TfNSW reference: REN25/00073/006, SF2025/042819

Your reference: SSD- 23515853

SSD-23515853, Armidale Battery Energy Storage System; Response to addendum Traffic Impact Assessment, Request for further information

Transport for NSW (TfNSW) is responding to the Addendum Traffic Impact Assessment (TIA) prepared by EMM dated 12 June 2025, Response to agency advice on Submissions Report and Amendment Report prepared by EMM dated 18 June for Armidale BESS, referred to TfNSW via the Major Projects Portal on 19 June 2025.

Figure 1: Pinch Point – OSOM vehicle traversing over median island at Jerry Plains Road off-ramp and Putty Road. Source: Drawing No. EMM-009 – Armidale Battery Energy Storage System OSOM assessment - Appendix A swept path assessments

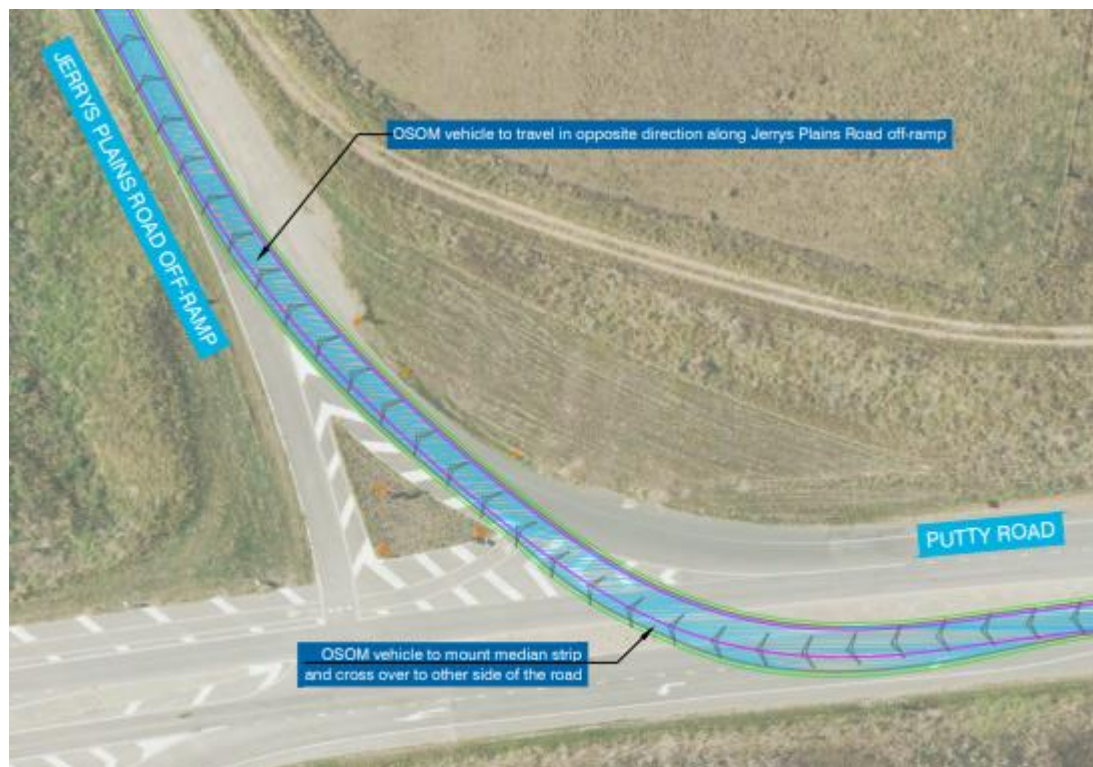
No.	TfNSW comments from RtS and Amendment response requiring RFI	TfNSW response to RTS, Amendment Report or RFI and request for further information for revised TIA
1	Provide a diagram of the laden dimensions, including the heights, widths, weights, and lengths of the check vehicle and load for the high-risk OSOM.	CLOSED: Diagram of high-risk vehicle provided.
2	Turn from Golden Highway onto Mount Thorley Road. The entry ramp appears close to the edge of the pavement. Provide a swept path analysis demonstrating that 0.5 m can be achieved from the wheel path to the edge of the pavement for this location.	CLOSED: Golden Highway onto Mount Thorley Road is not proposed to be used as part of the high-risk OSOM route.

Figure 2: Pinch Point – OSOM vehicle traversing over median island at New England Highway/ Scott Road, Tamworth. Source: Drawing No. EMM-023 – Armidale Battery Energy Storage System OSOM assessment - Appendix A swept path assessments

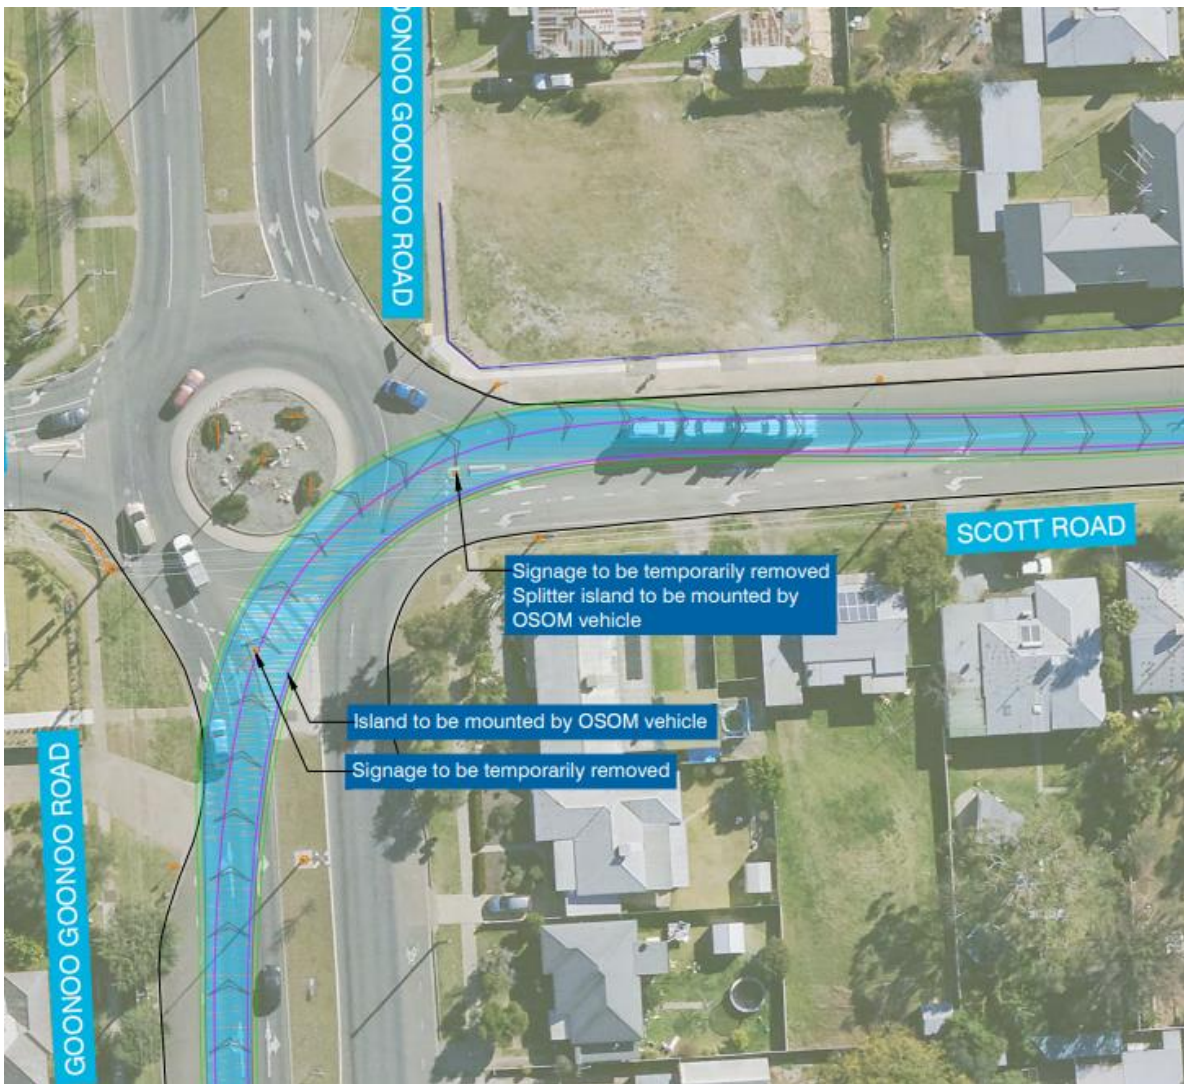
<p>6</p>	<p>Strategic concept designs are to be prepared and included within the revised TIA for the road works proposed to the centre islands of the New England Highway/Oxley Highway, which are identified within the route analysis as a requirement for the high-risk OSOM-laden vehicle configuration to navigate this pinch point</p>	<p>OPEN:</p> <p>Armidale BESS proposes to traverse median or refuge island at 6 locations on the state road network (see figures within Attachment B for locations), using a rubber mat and steel protection method to safeguard the medians. This method cannot be supported by TfNSW.</p> <p>The revised TIA is to detail the scope of the modifications to the median(s) required to ensure that the high-risk OSOM can negotiate the pinch point(s) on the state road network without damaging the state road infrastructure.</p> <p>If traversing of the medians on the state road network cannot be avoided, then strategic concept designs will be required that identify the scope of the works that would be necessary to ensure the median could be traversed and withstand the mass of the high-risk OSOM movement (i.e pavement strengthening). Strategic concept designs will need to be submitted to identify the extent of the road upgrades, or provide a strategic concept design that identifies the temporary or partial removal of the median, in accordance with Austroads and TfNSW requirements, that will allow for the high-risk OSOM to navigate through this pinch point.</p> <p>Note: Temporary removal will need to include the length of time for removal, any interim treatments (e.g., line marking), and when and what will replace the median post-completion of high-risk OSOM movement. Alternative options to avoid traversing the state road network infrastructure include changing the route or modifying the high-risk OSOM vehicle configurations.</p> <p>Note: TfNSW advises that changing the route and changing the vehicle configuration of the high-risk OSOM could potentially increase the scope of works required on the public road network.</p>

Figure 4: Pinch Point – OSOM vehicle traversing over refuge island at Kentucky Street, Armidale. Source: Drawing No. EMM-031 – Armidale Battery Energy Storage System OSOM assessment - Appendix A swept path assessments

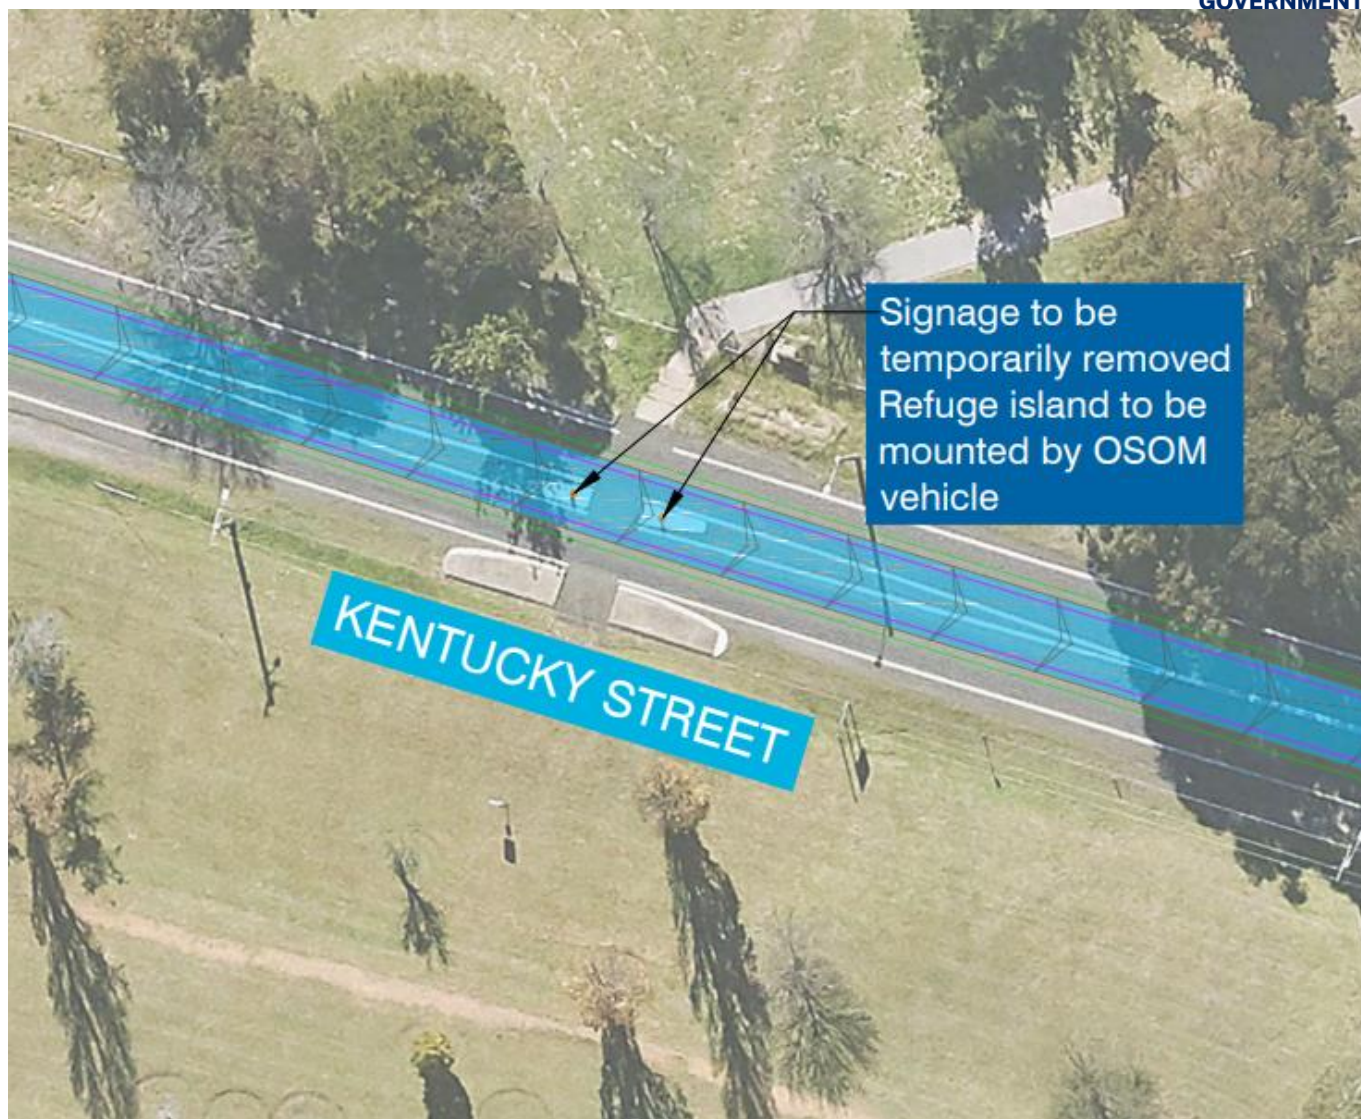
7	<p>Strategic concept designs are to be prepared and included within the revised TIA for the road works proposed to the centre islands of the Waterfall Way/ Canambe Street, which are identified within the route analysis as a requirement for the high-risk OSOM-laden vehicle configuration to navigate this pinch point.</p>	<p>CLOSED:</p> <p>The report states that hardstands required at the Waterfall Way/Canambe Street roundabout and that the design will be to TfNSW standards. The impacted kerb, grassed road reserve and footpath at that location are Council assets so it will be for Council to determine the requirements</p>
8	<p>The project proposes to use the route via Sydney Road and under the rail underpass through Muswellbrook. The rail underpass has height and horizontal geometric limitations, such as barriers and other infrastructure, that need to be reviewed to assess whether traversing underneath the rail overpass on Sydney Road would be a viable option as a high-risk OSOM route based on the project-laden height, width, and length for the high-risk OSOM-laden vehicle configuration. TfNSW notes that the route analysis has considered the alternative route via Bell Street. TfNSW requires point 7 to be addressed and confirm whether both options will continue to form part of the project's high-risk OSOM routes through Muswellbrook.</p>	<p>CLOSED:</p> <p>The high-risk OSOM route analysis no longer includes the use of Sydney Road within Muswellbrook, as part of the route.</p>
